Application No: BE/63/20/HH
Site Address: 414 Chichester Road Bersted PO21 5DR
Description of works: Conversion of garage to one bed annex with single storey extension.

Thank you for your internet representation made on 4th September 2020 which has been recorded as an objection with the comments as follows:

GROUND FLOOR PLAN
[As Proposed]

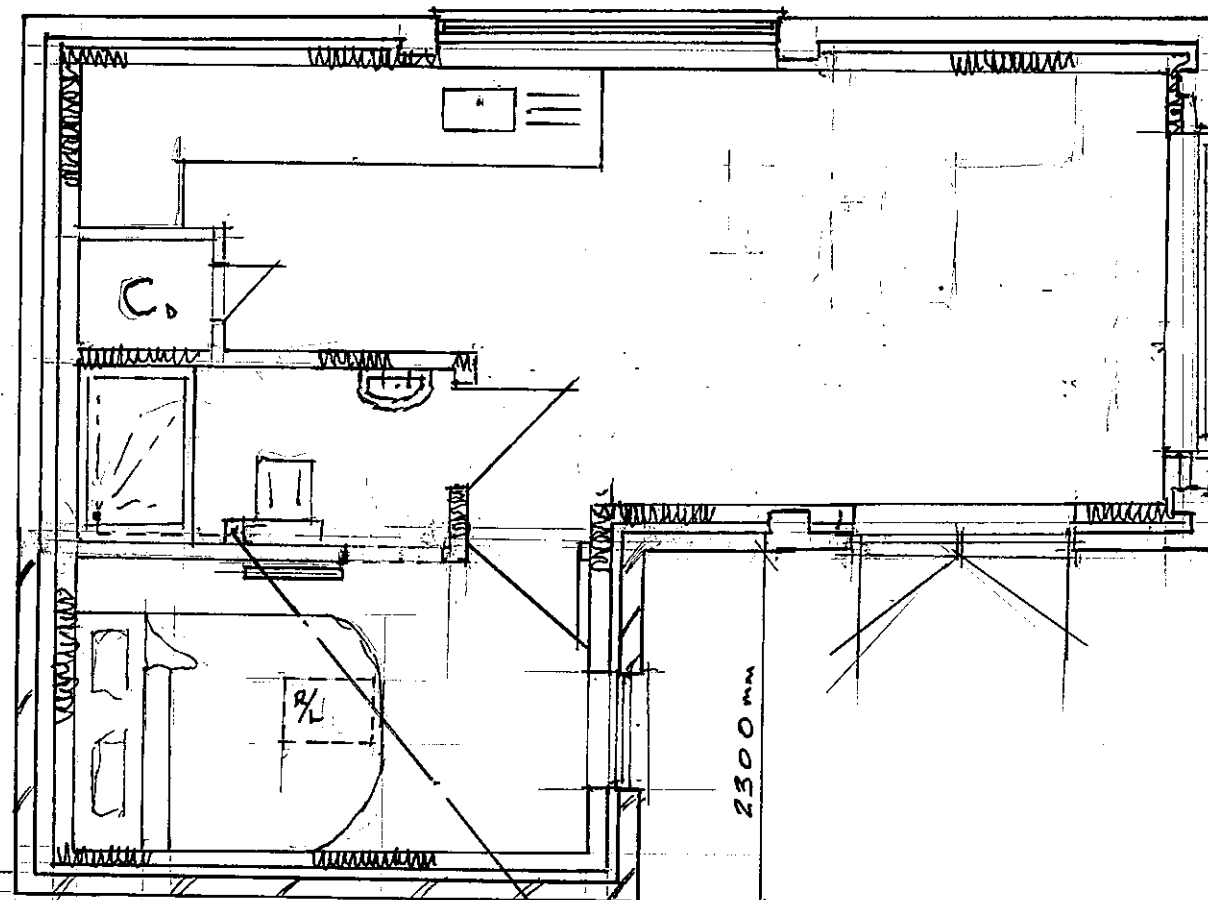
We are extremely concerned that due to the requested layout of the extension it will affect the light into our garden considerably.

Furthermore, as the extension is planned against our wall, please can you advise how you intend to carry out this conversion and general maintenance without affecting or needing permission to use our land.

If approved, would it be possible to consider having this extension against their other wall, the outer wall, therefore not affecting the light entering our garden as much.
